## REVISION/DEFERRED SUBMITTAL FORM

Site Address 8455 SE 83rd Street

Permit Number 2208-260-SUB-1

Date March 31, 2023  
To City of Mercer Island  
Community Planning & Development  
From Chris Haddad  
Permit Number **2208-260-SUB-1**  
Project Address 8455 SE 38rd Street  
Mercer Island, WA 98040  
Reference **Jaffe Residence - Revisions to a plan currently in review**

Drawing Title  
**SITE PLAN**

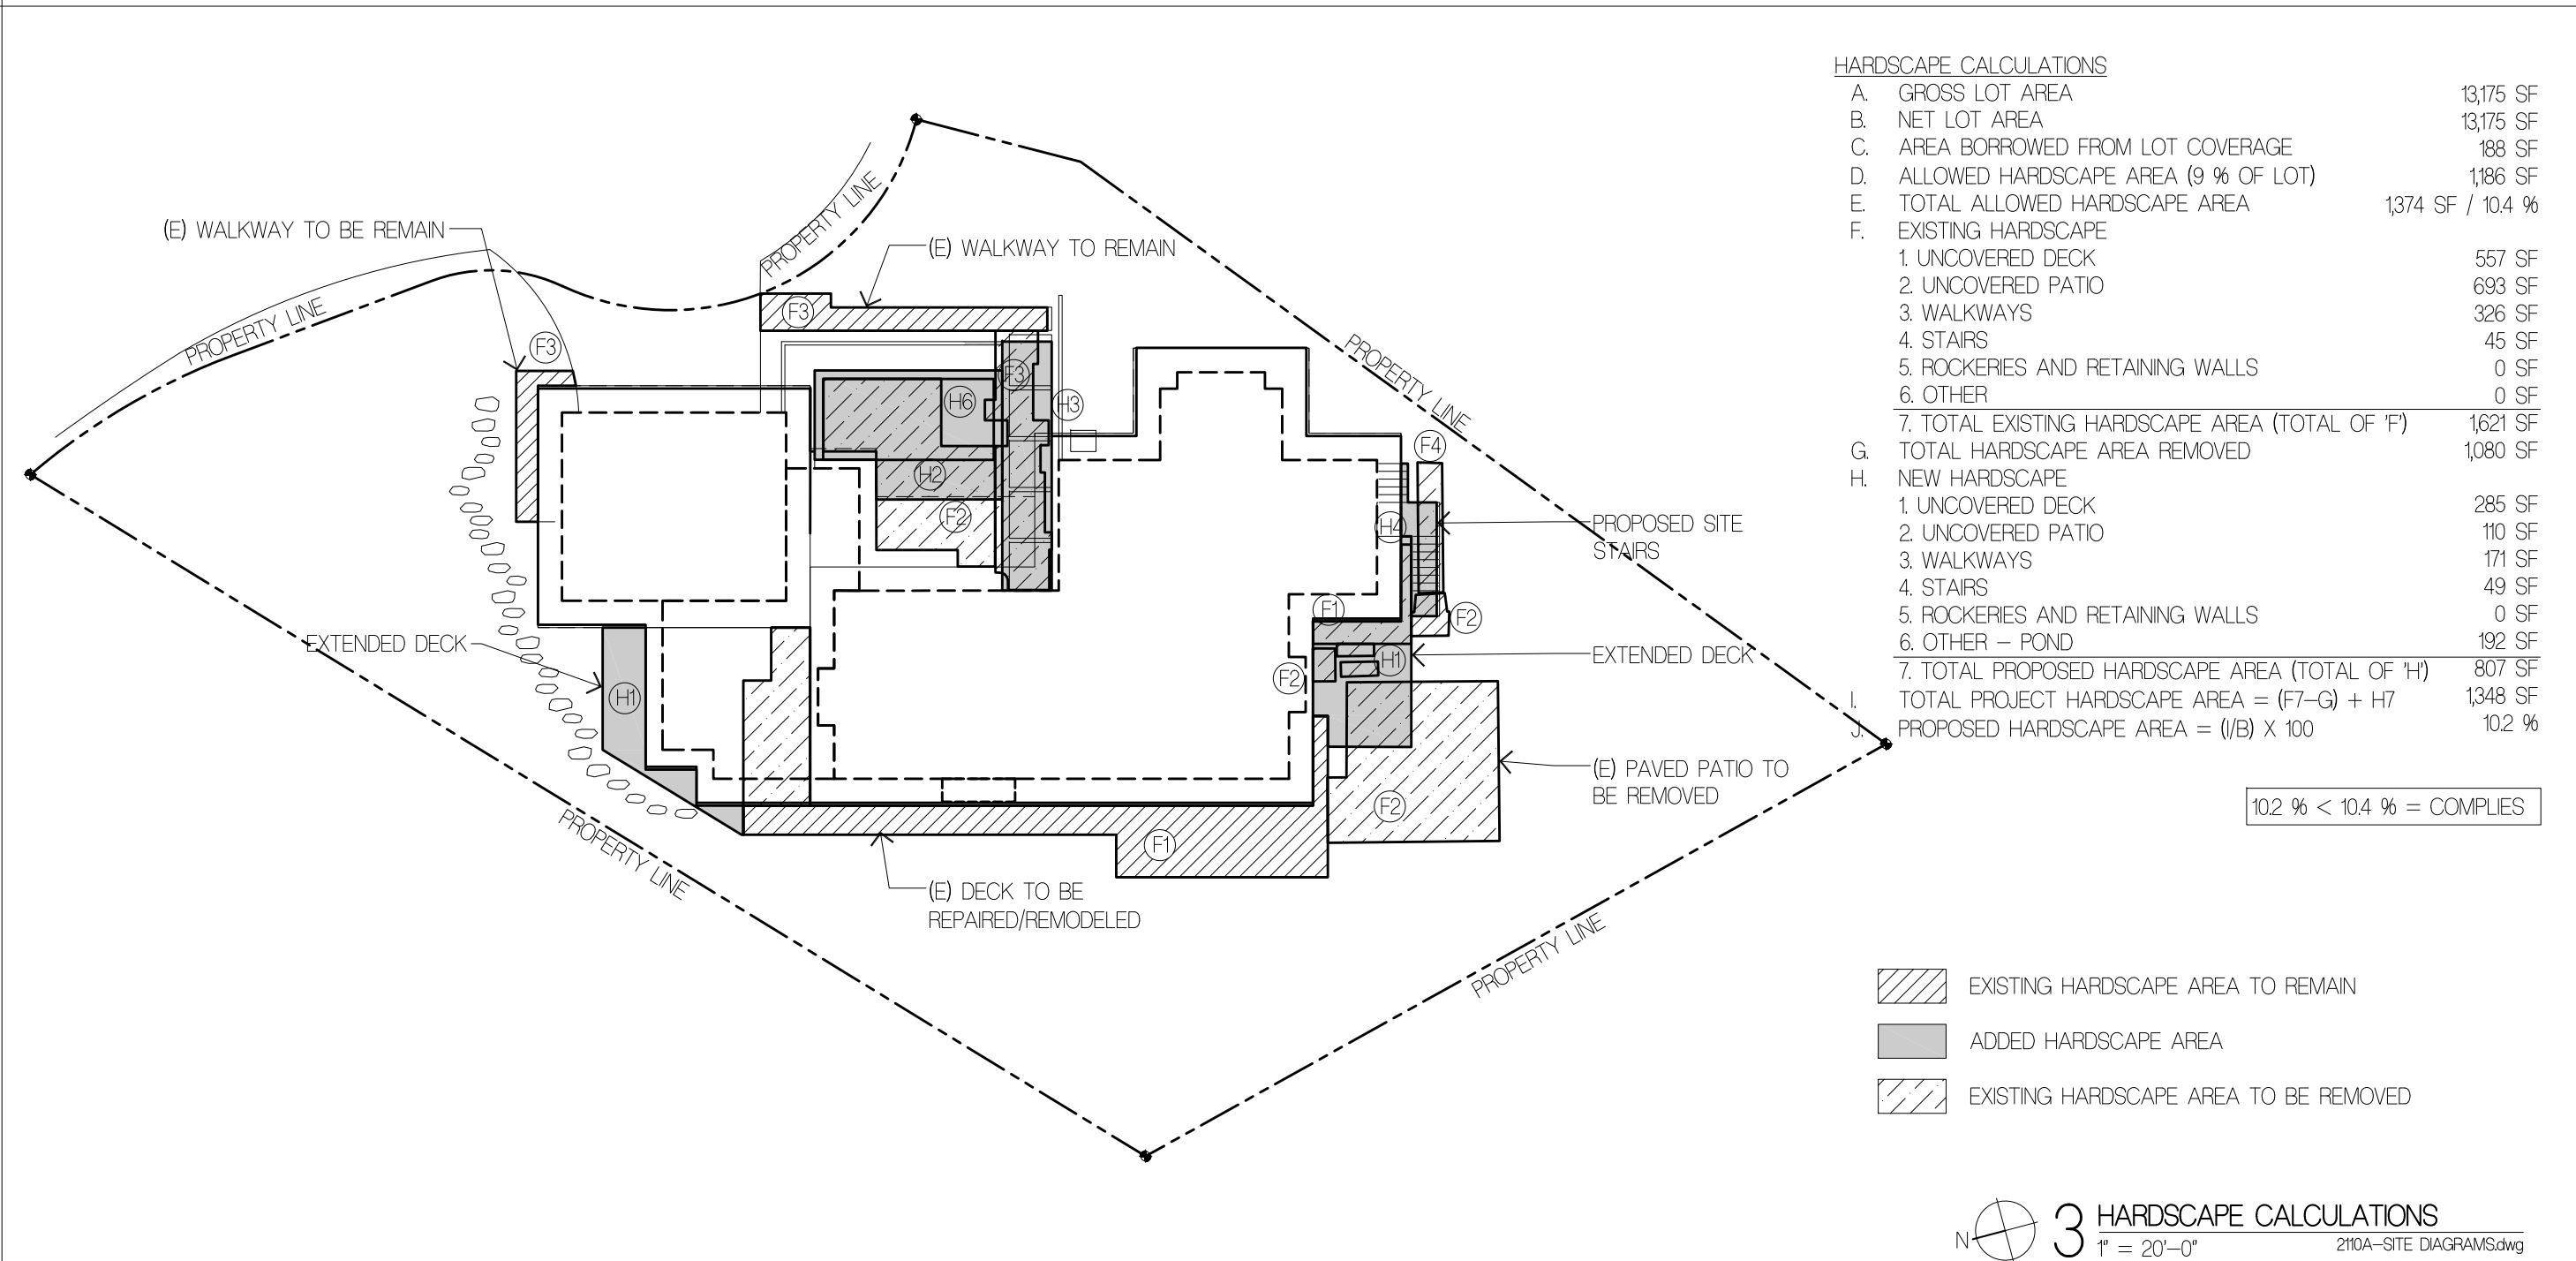
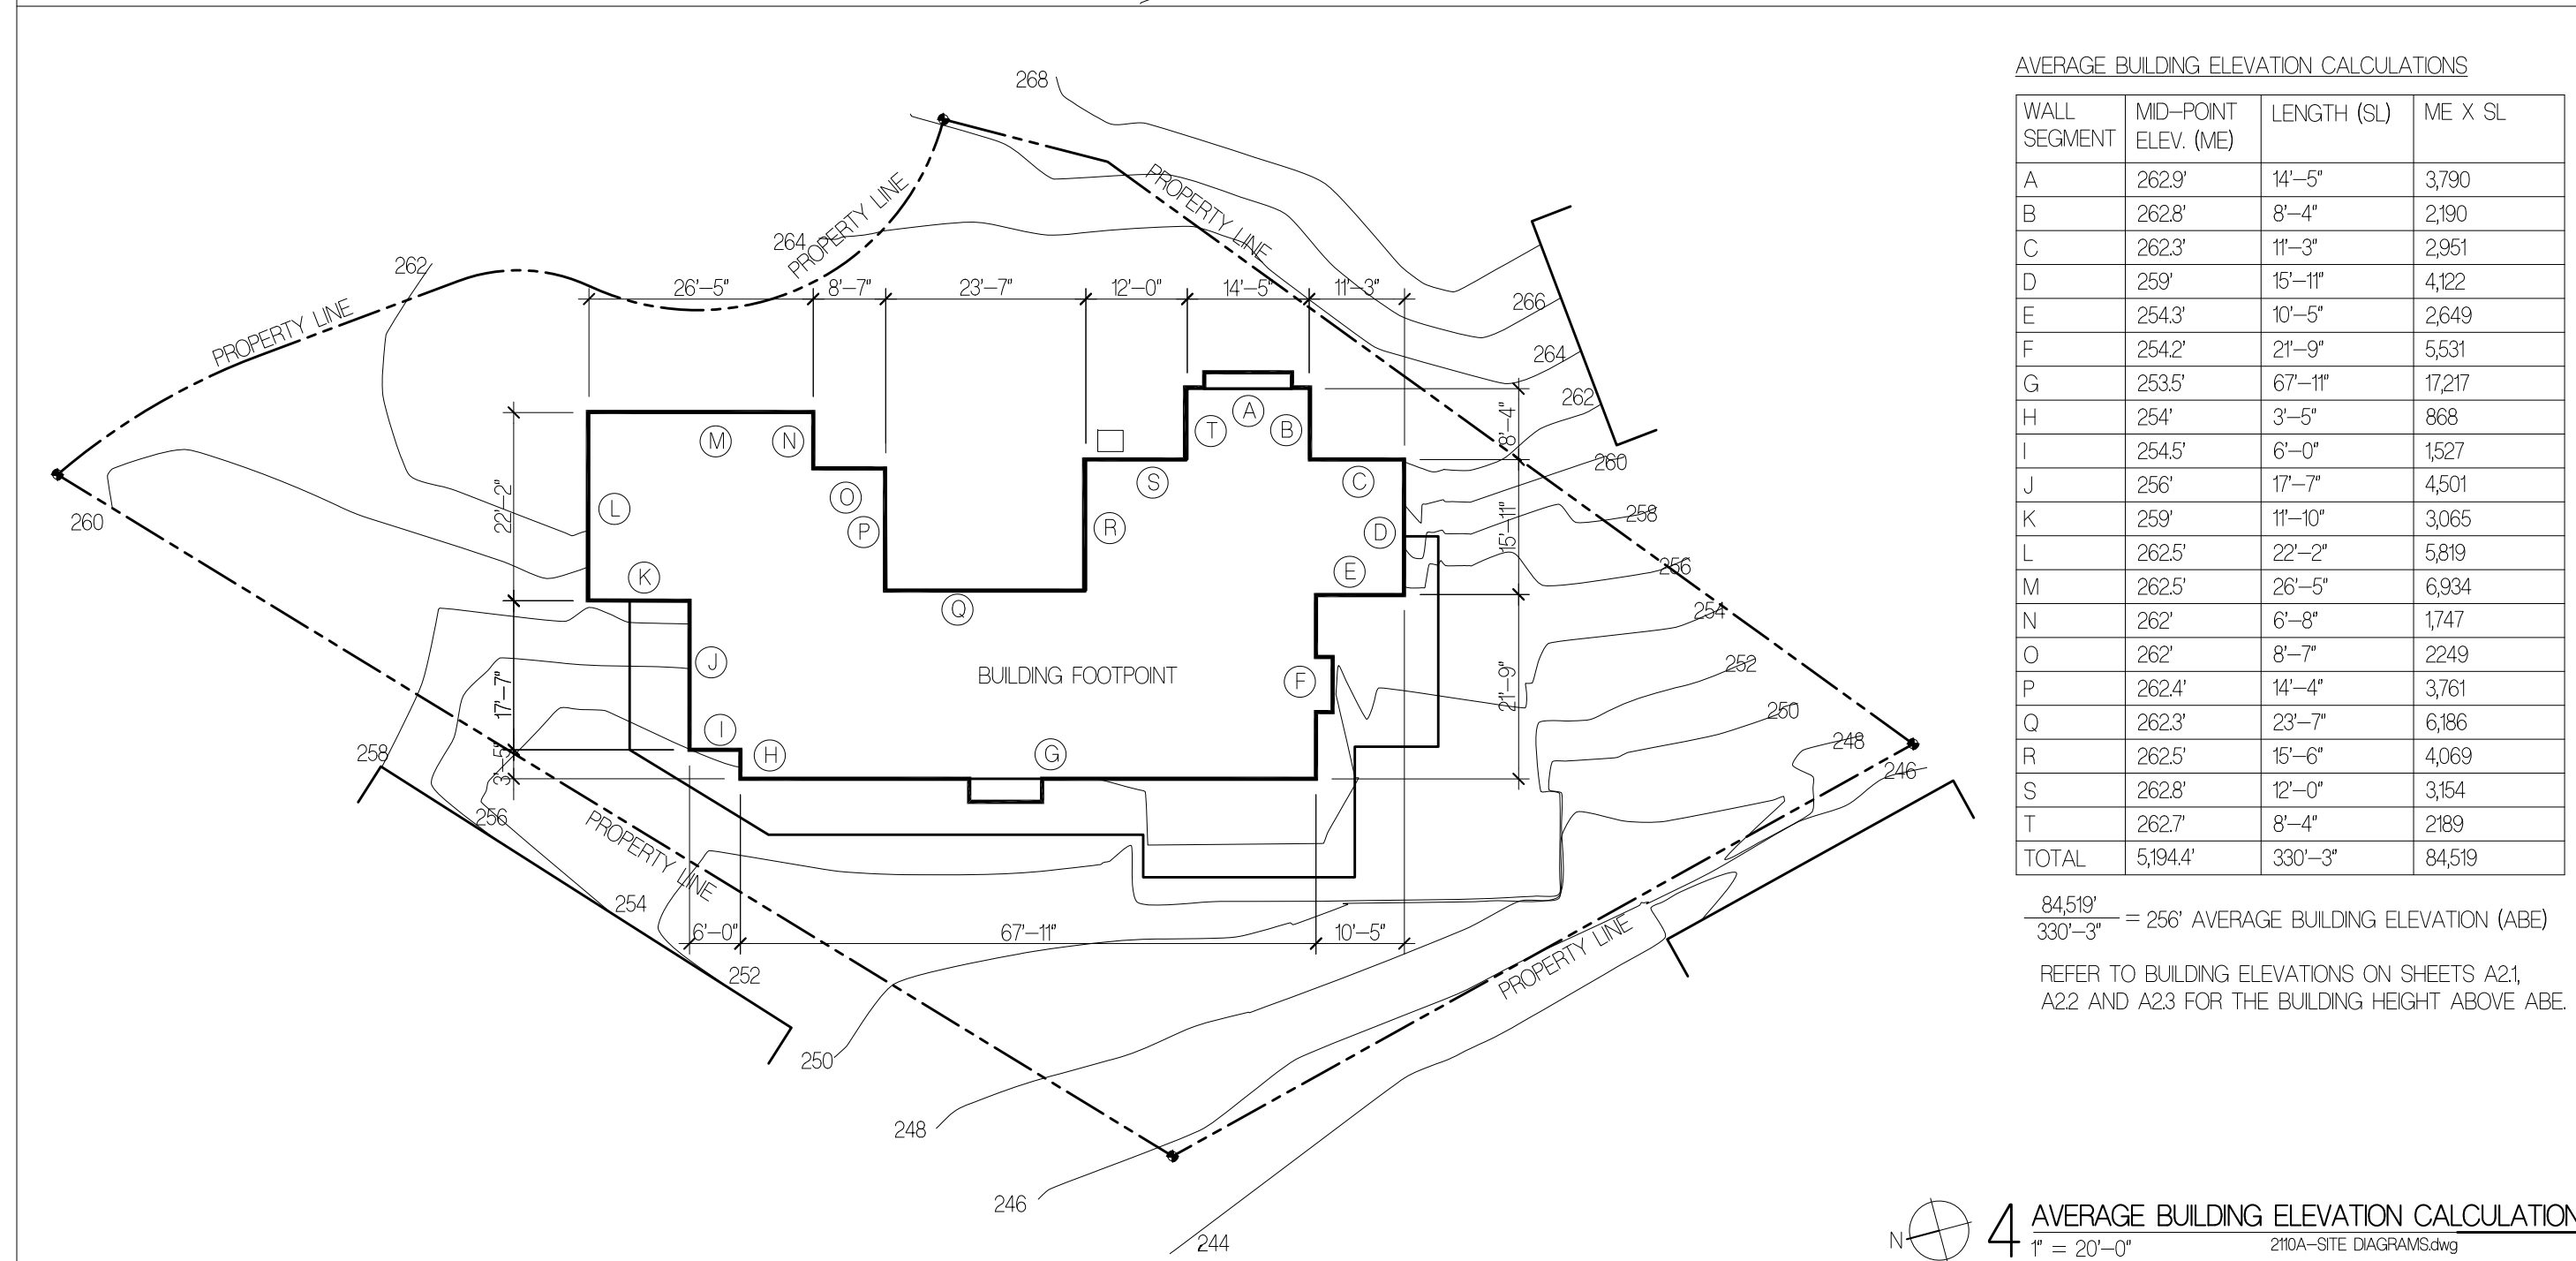
- Mudroom addition to the south of the (E) garage has been eliminated. The addition to the west of the (E) garage has been reconfigured.
- The addition of the deck has been reconfigured. The deck & stair addition at the south end of the house has been eliminated. The deck addition at the north end of the house has been slightly enlarged. We have discussed this with the Arborist and she confirmed this revision will not impact the (E) tree #347. Refer to the attached report for her investigations at this tree. The (E) deck from the Primary Bedroom is now proposed to be removed.
- The proposed water feature in the front yard has been eliminated, we are proposing landscaping in that area instead.
- The new concrete terrace outside of the Basement Level Family Room has been eliminated.
